# Memo.

**Subject:** S6/2011/2782/FP – 97 Bramble Road, Hatfield

**Erection of single storey rear extension, first floor side and single storey front extensions and loft conversion with skylight windows to front, side and rear elevations**

TITLE
**PROPOSED
BLOCK PLAN**

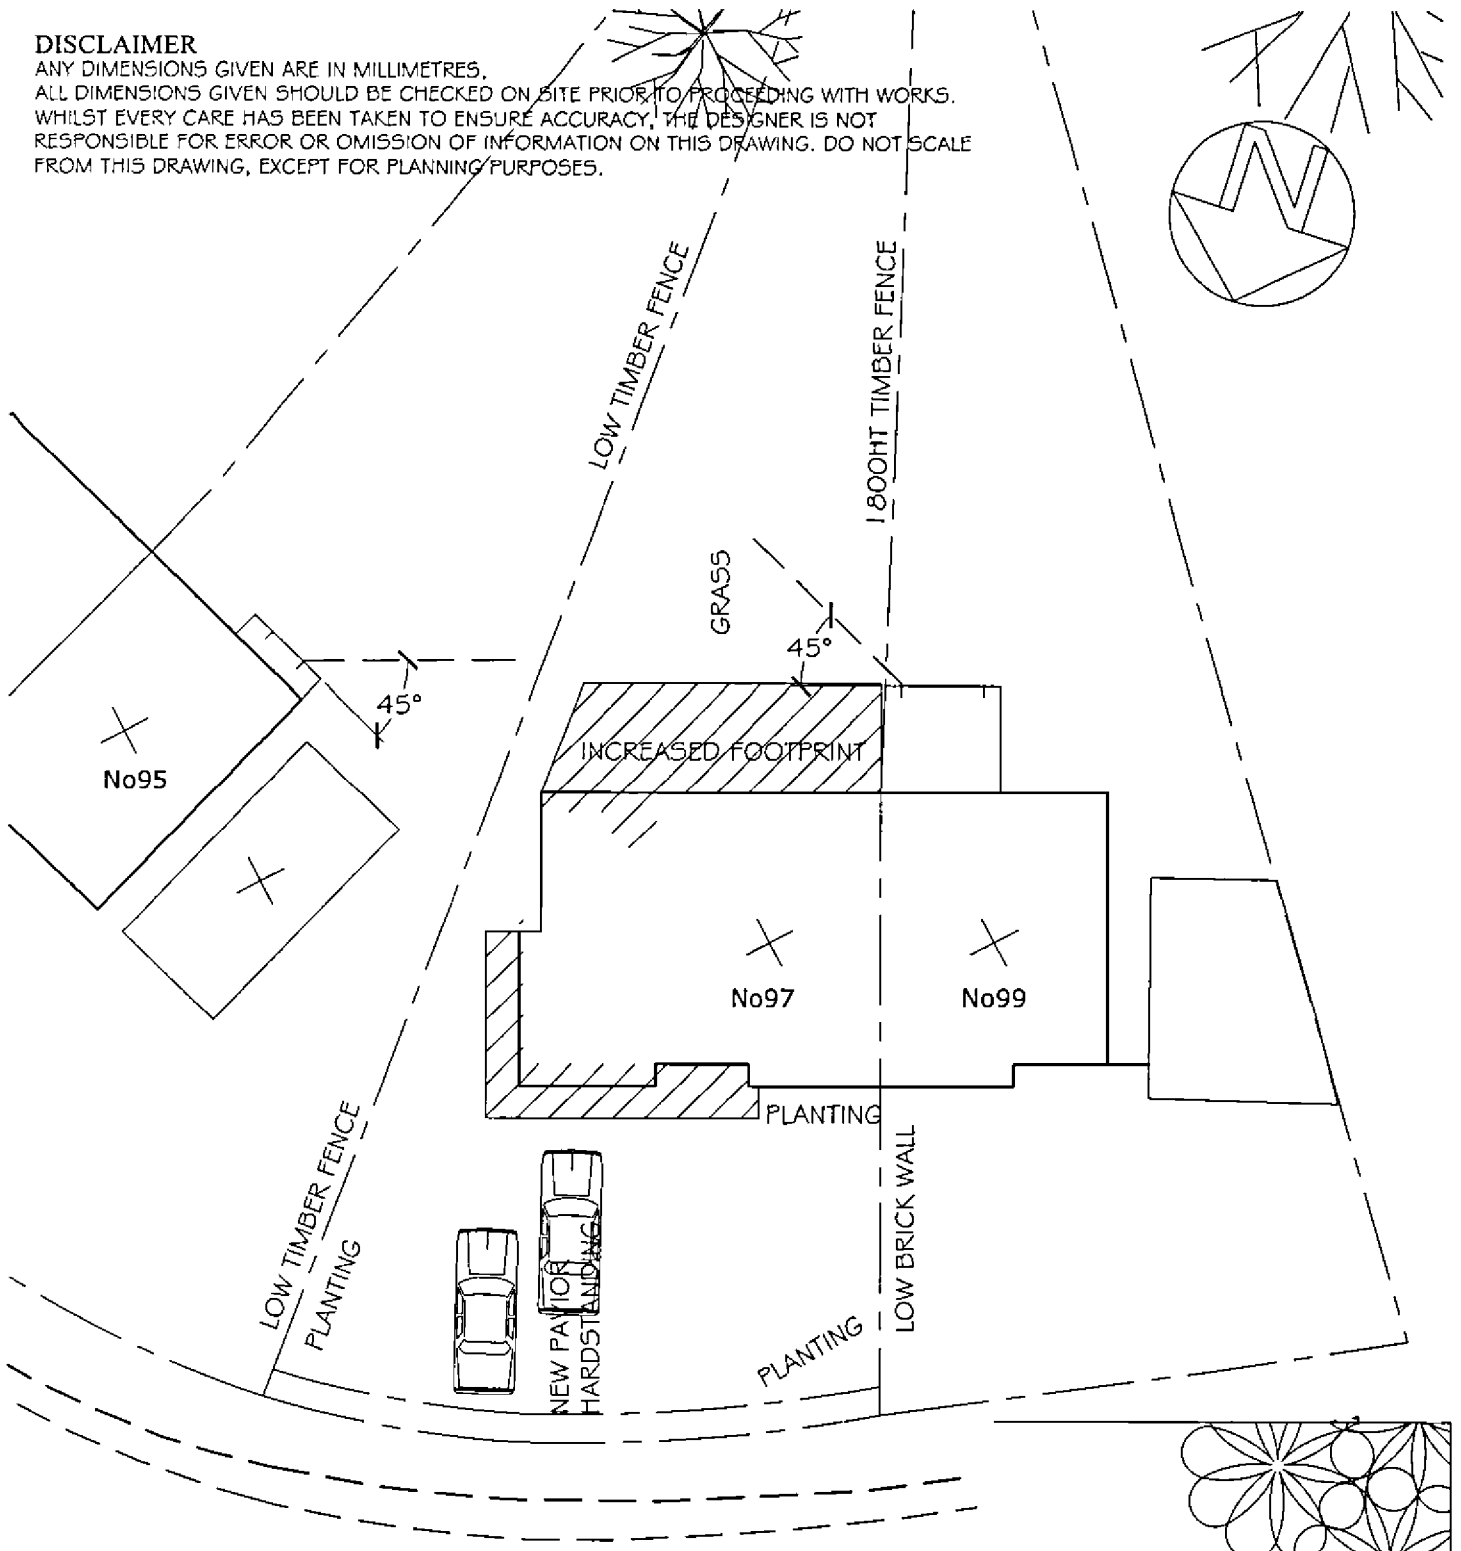
There is one tree within the front garden which is young and small. If this tree is to be kept through the construction period, the applicant should bear in mind that excavation or compaction of the soil close to trees can damage the roots and/or soil and be potentially harmful. Care must be taken whilst working around them, guidance can be sort from BS5837:2005 Trees in Relation to Construction or from a arboricultural or landscape professional.
